April 20, 2018

Site Plan 2017-278

Zoning Review of the Height of the proposed structure

**FRONT ELEVATION**

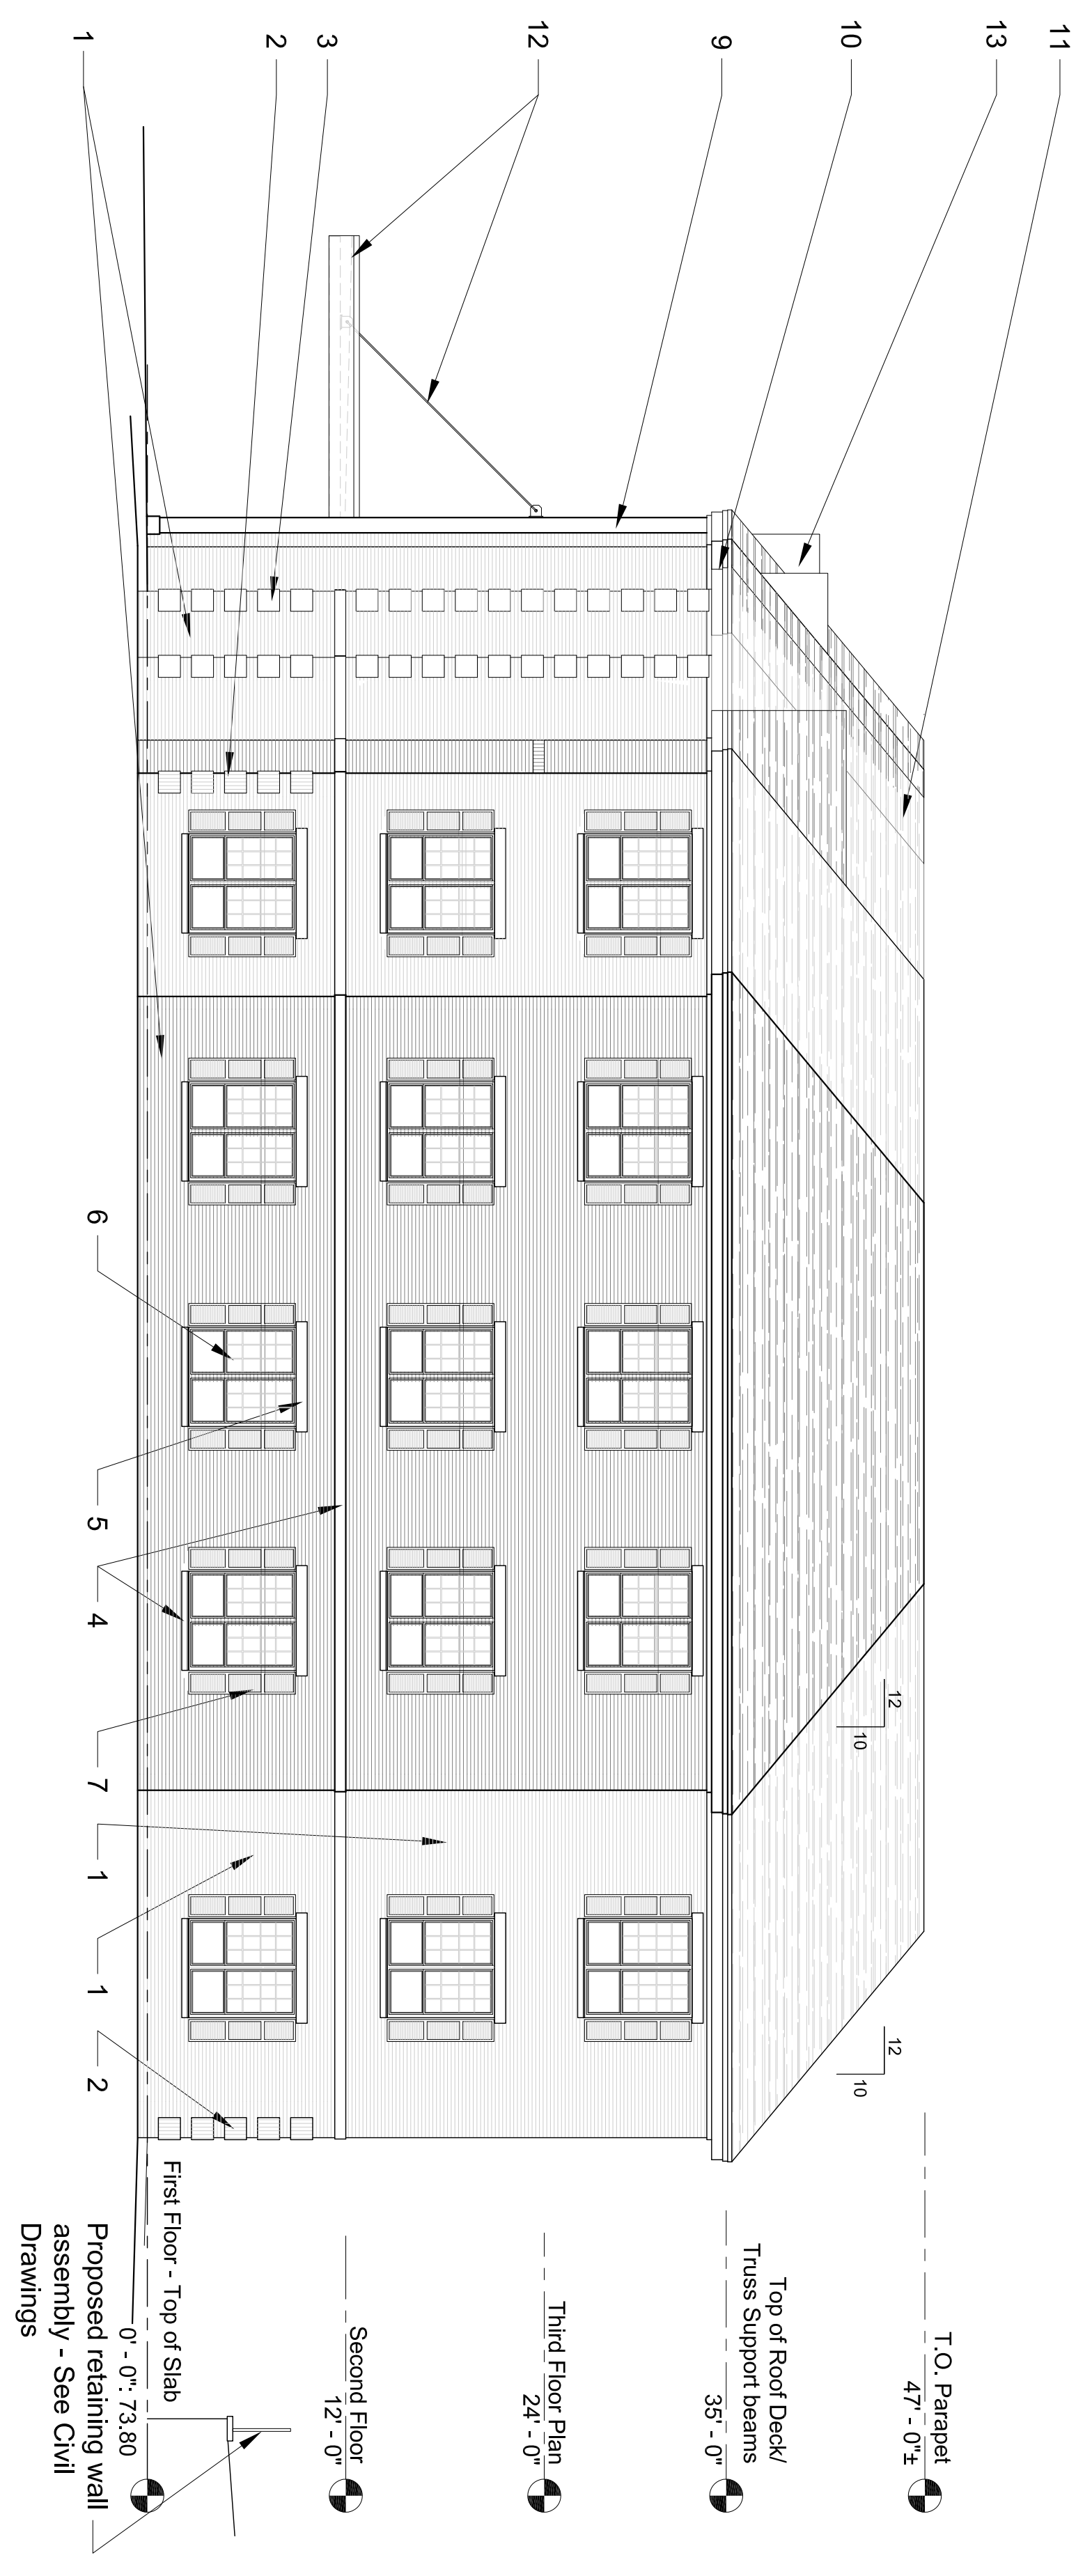
The Adjacent Building Grades Plan by Wright Pierce, dated April 2018 (attached) shows the average grade for the building as 73.80 feet based on the proposed grade at the four corners of the building. On Plan A1.01 – Proposed Building Elevations revised 03.20.208 (attached) the Front Elevation shows the average grade line across the building at 73.80 feet. The “Top of Roof Deck/Truss Support beams” is shown as 35 feet above the average grade line. Based on these two plans, the building appears to meet the maximum height requirement of 35 feet.
